Rezoning Petition Review

Rezoning Petition #: 19-156

Location of Property: Approximately 0.52 acres located at the southwest intersection of Parkwood Ave and Pegram St.

Recommendations Concerning Storm Water (Revised 4/29/20):

**REZONING PLAN 2019-156**

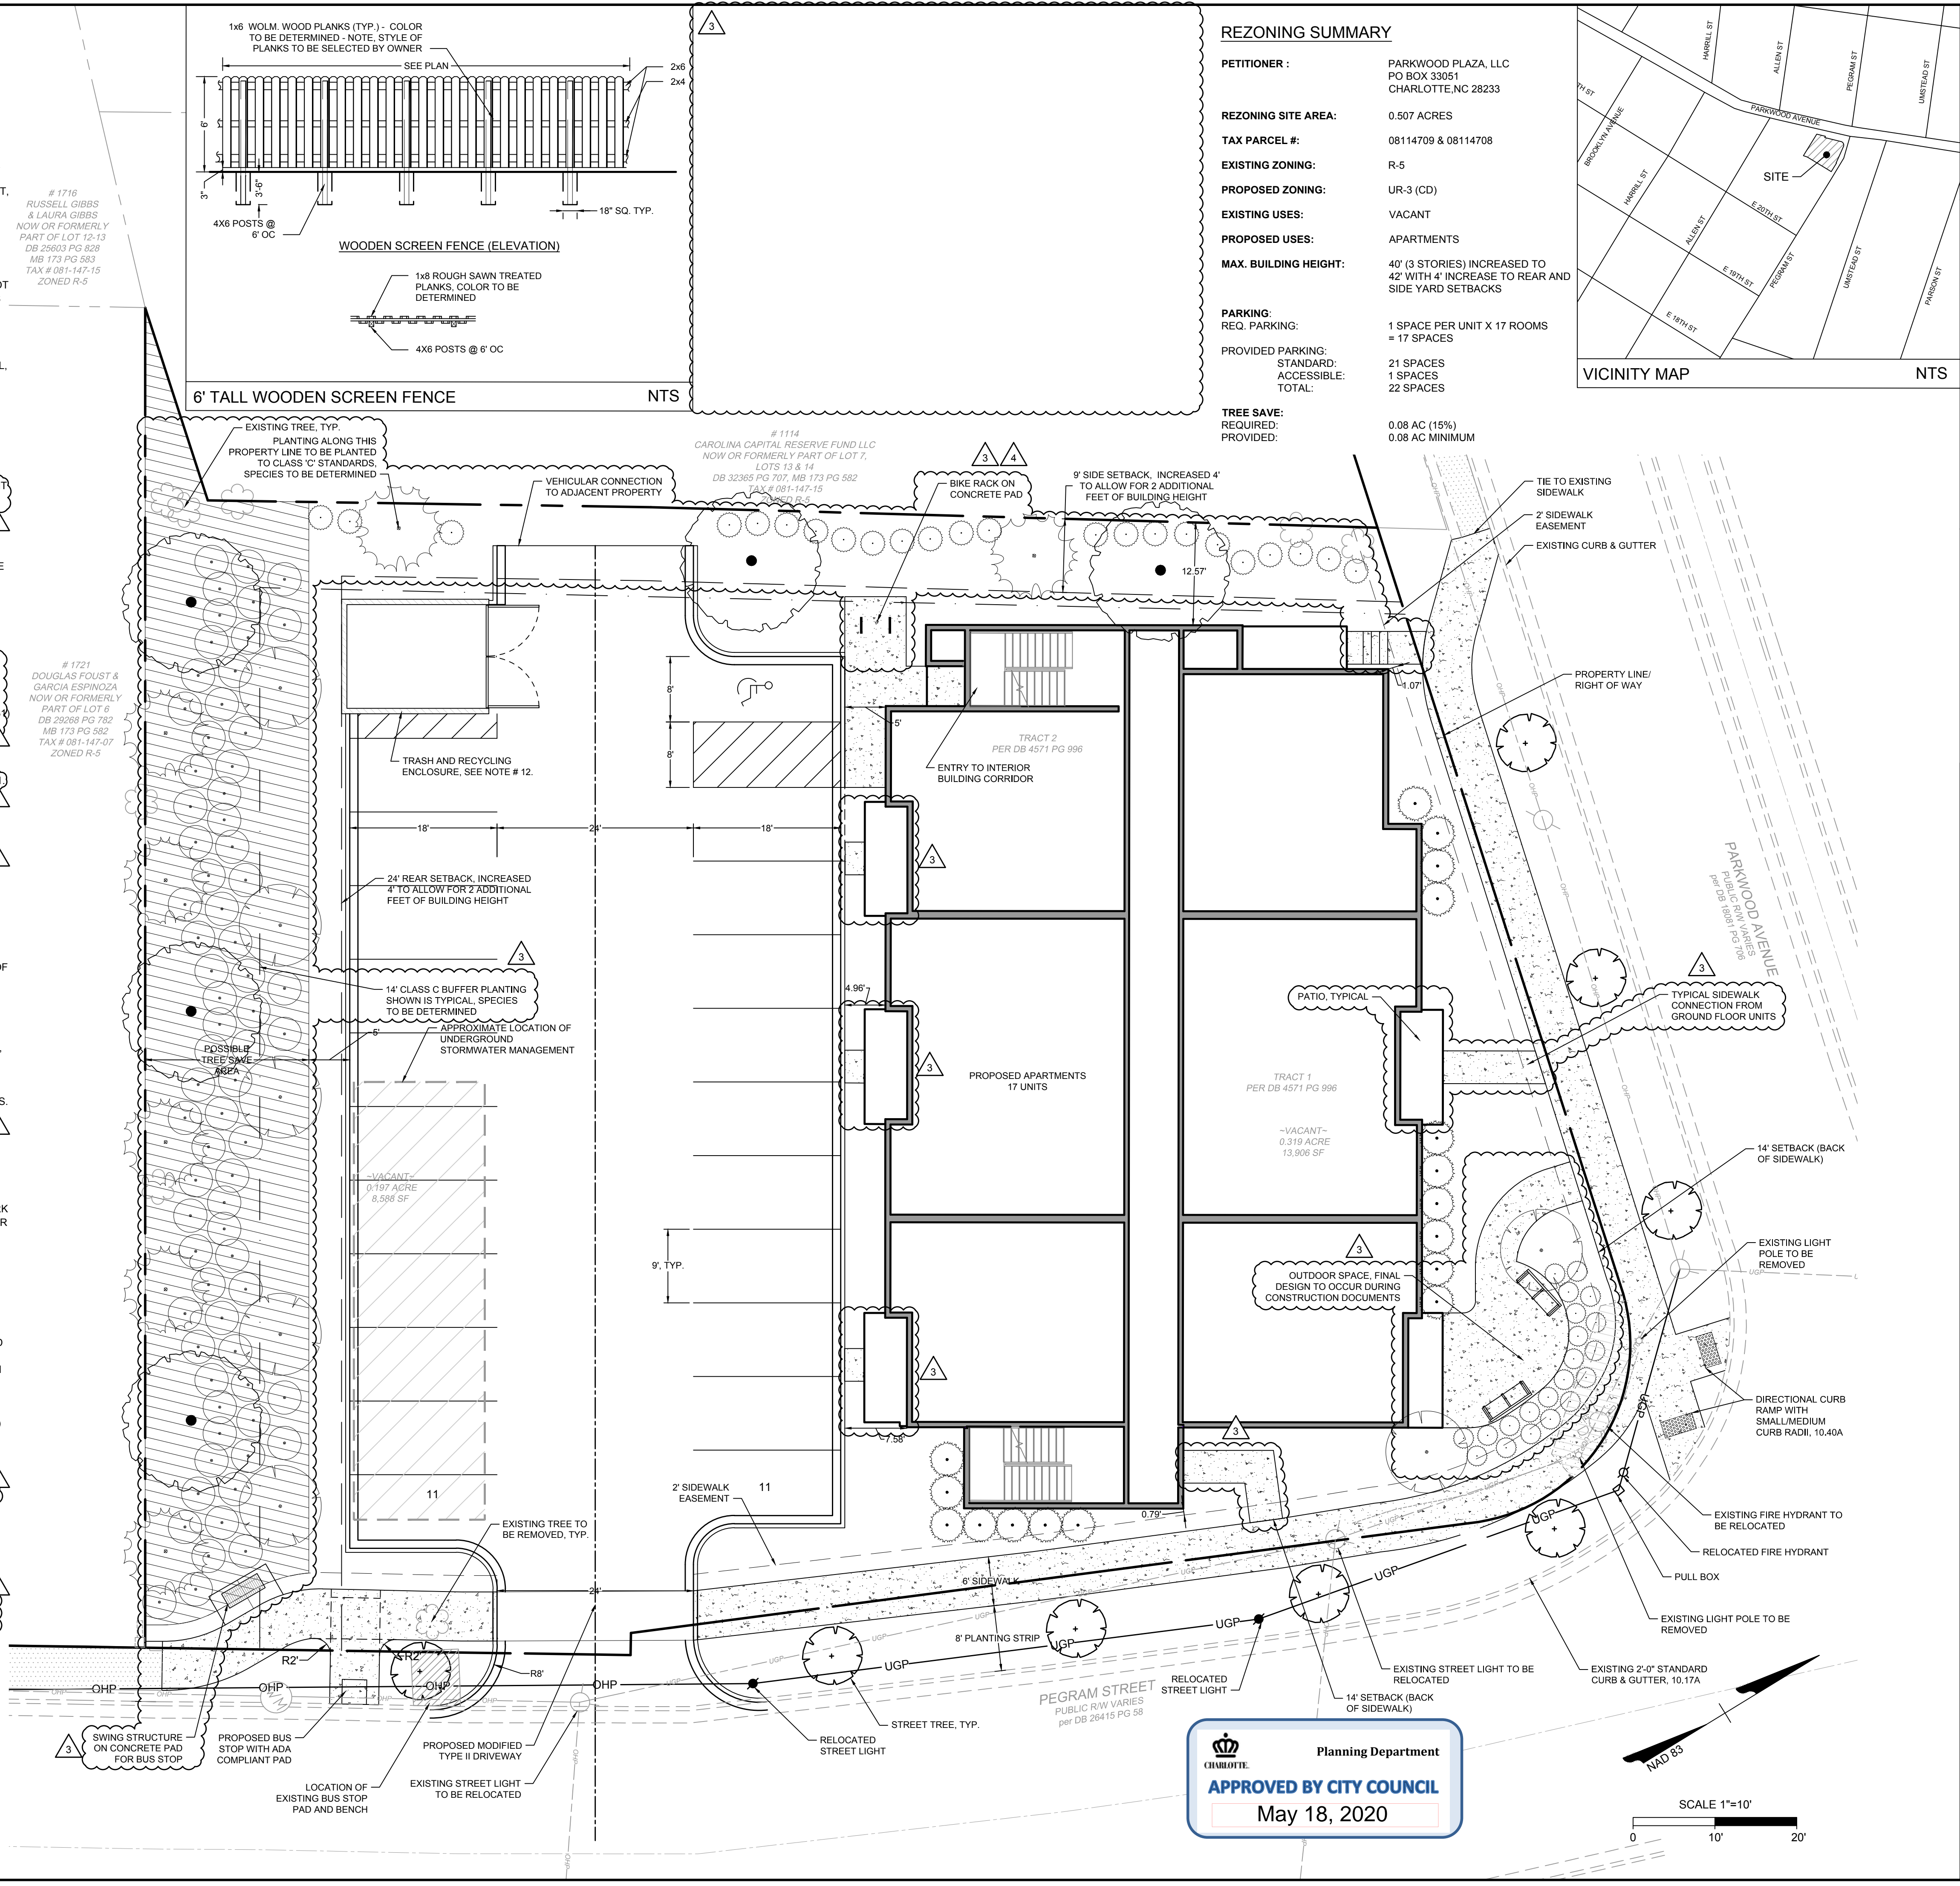
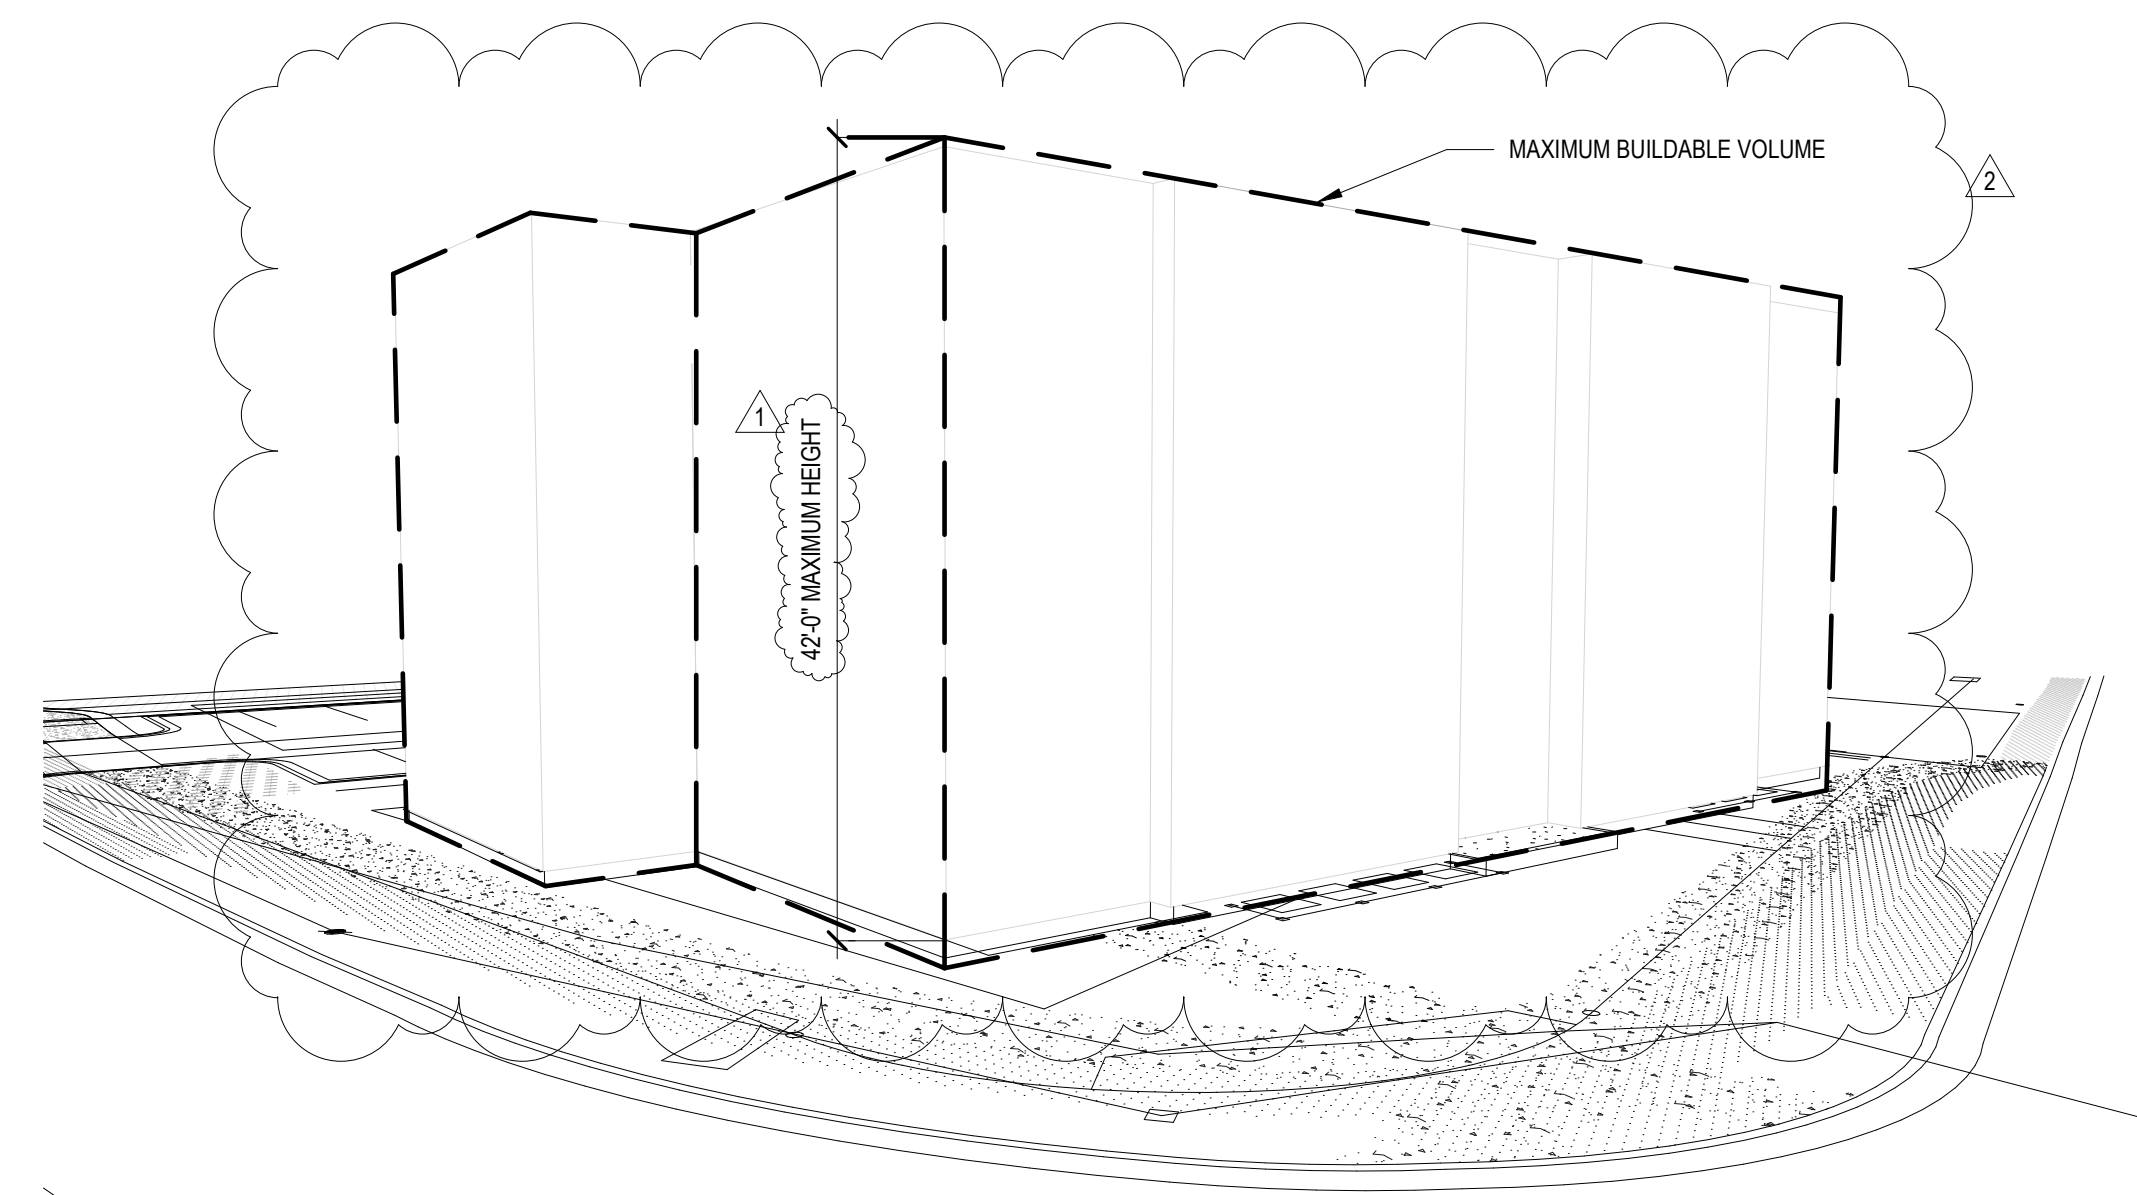
This property drains to Upper Little Sugar Creek, which is an impaired/degraded stream, and may contribute to downstream flooding. This project has the opportunity to mitigate future impacts to this stream, therefore, Storm Water recommends placing the following notes on the plan:

For defined watersheds greater than 24% built-upon area (BUA), construct water quality stormwater control measures (SCMs) designed for the runoff generated from the first 1-inch of rainfall for all new and redeveloped BUA associated with the project. SCMs must be designed and constructed in accordance with the Charlotte-Mecklenburg BMP Design Manual.

For defined watersheds greater than 24% built-upon area, control the entire volume for the 1-year, 24-hour storm for all new and redeveloped BUA associated with the project. Runoff volume drawdown time shall be in accordance with the Charlotte-Mecklenburg BMP Design Manual.

For commercial projects with greater than 24% BUA, control the peak to not exceed the predevelopment runoff rates for the 10-yr, 6-hr storm and perform a downstream flood analysis to determine whether additional peak control is needed and if so, for what level of storm frequency, or if a downstream analysis is not performed, control the peak for the 10-yr and 25-yr, 6-hour storms.

For residential projects with greater than 24% BUA, control the peak to not exceed the predevelopment runoff rates for the 10-year and 25-year, 6-hour storms or perform a downstream analysis to determine whether peak control is needed, and if so, for what level of storm frequency.
